Application Ref:	2025/0675			 Ribble Valley Borough Council www.ribblevalley.gov.uk
Date Inspected:	Various.	Site Notice:	25/09/2025	
Officer:	EP			
DELEGATED ITEM FILE REPORT:				APPROVAL

Development Description:	Proposed replacement roof structure including demolition of chimney stack to create two additional bedrooms and shower room and introduction of Juliet balcony to northern side gable.
Site Address/Location:	Holly House, 8 Station Road, Rimington BB7 4DR.

A2.2

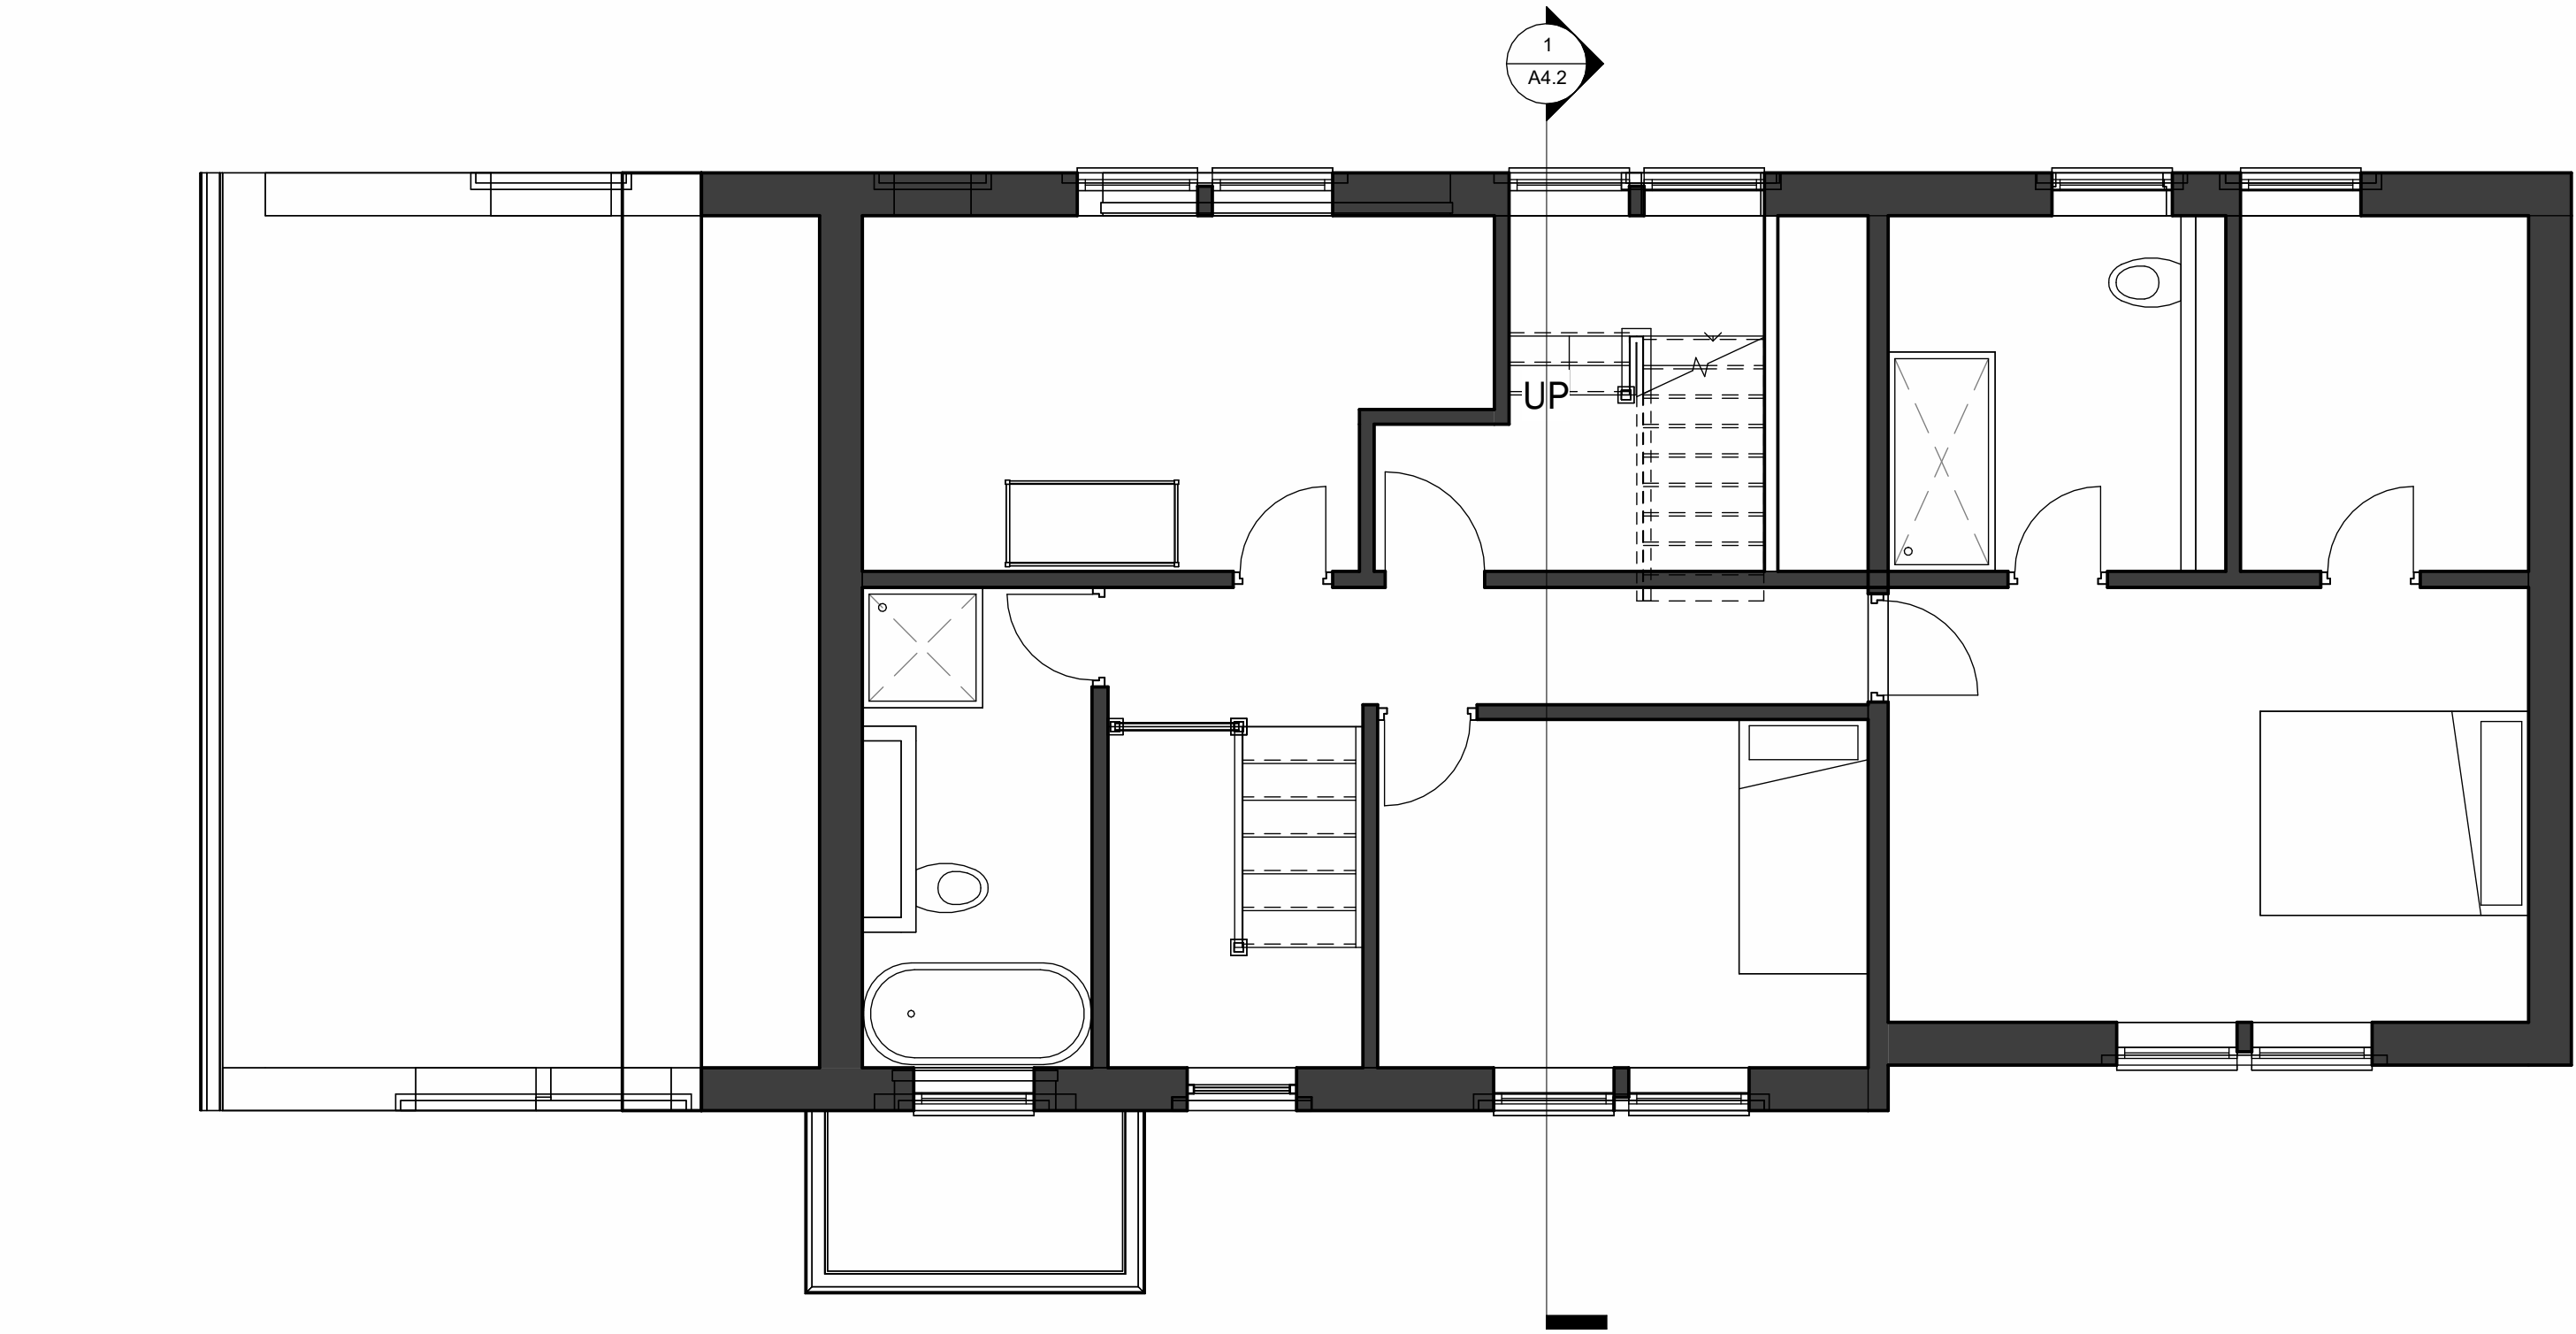
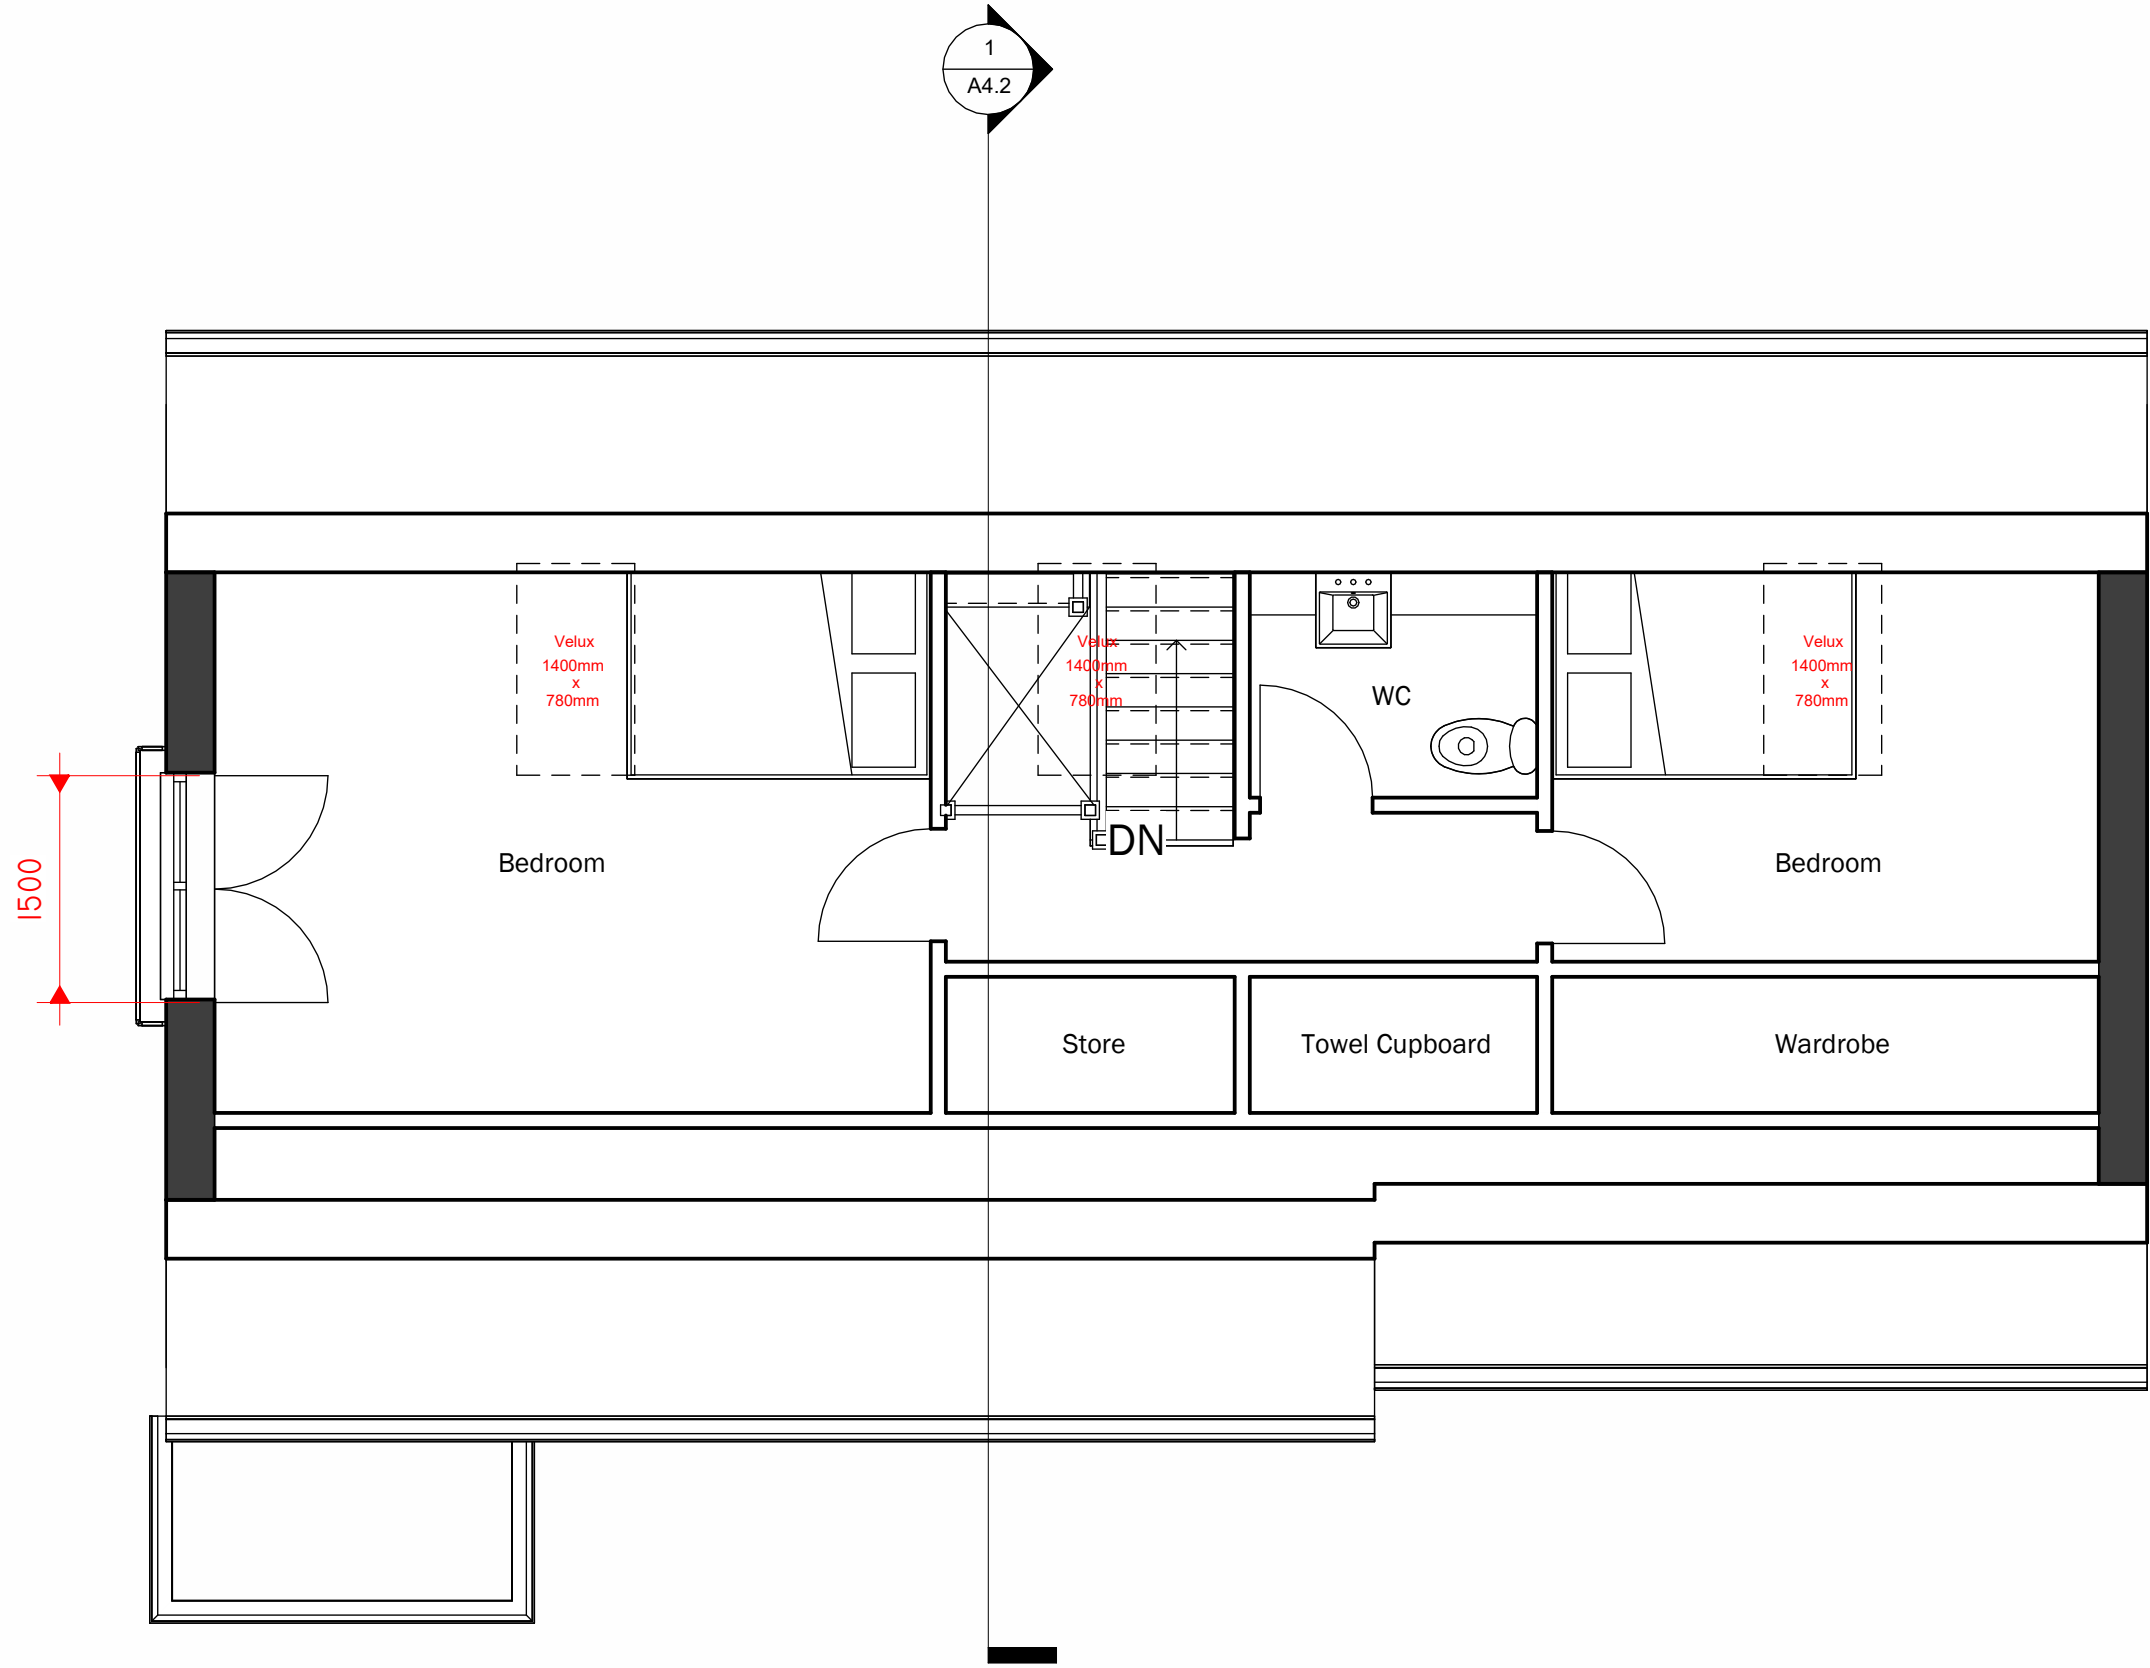
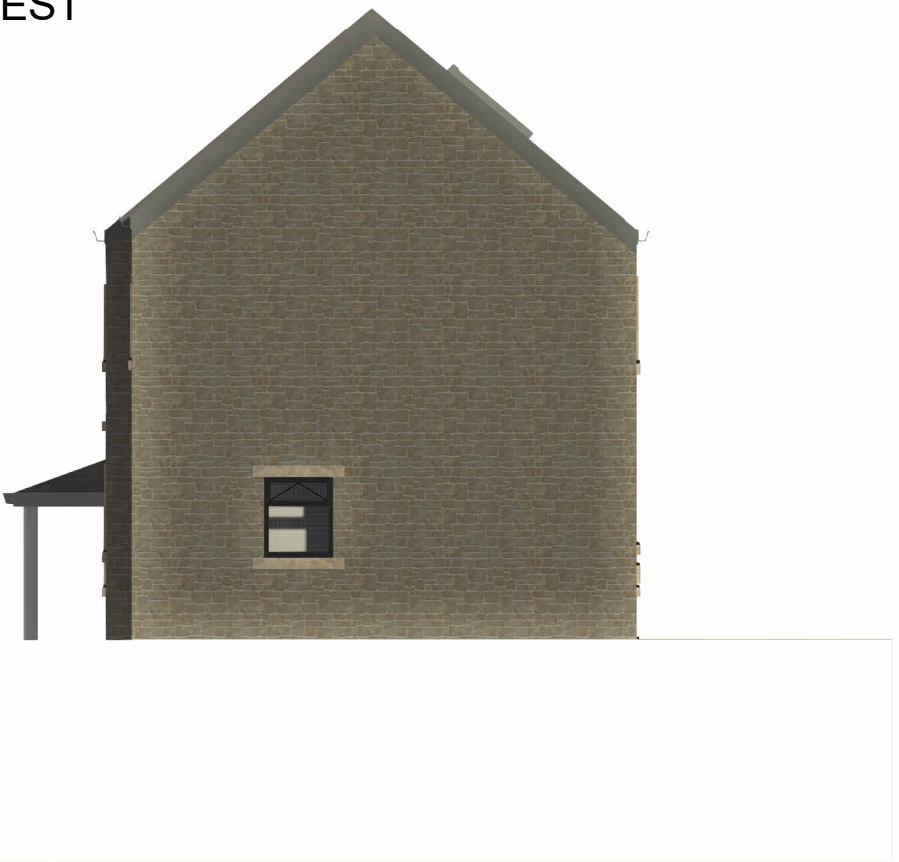
The proposed Juliet balcony is located in the northern side elevation of the dwelling and as such would be highly visible from within the public realm. The size of the glazed opening is appropriate to the scale of the dwelling and existing fenestration. Given the balcony is a Juliet style, it is not a prominent addition to the dwelling and will integrate sufficiently into the property.

The existing roof slope is relatively shallow, as a result the roof will need to be heightened to accommodate additional storey living accommodation. The ridge will be increased by approximately 1m, given the shallow nature of the existing roof it is not considered that this alteration would look disproportionate or anomalous within the streetscape.
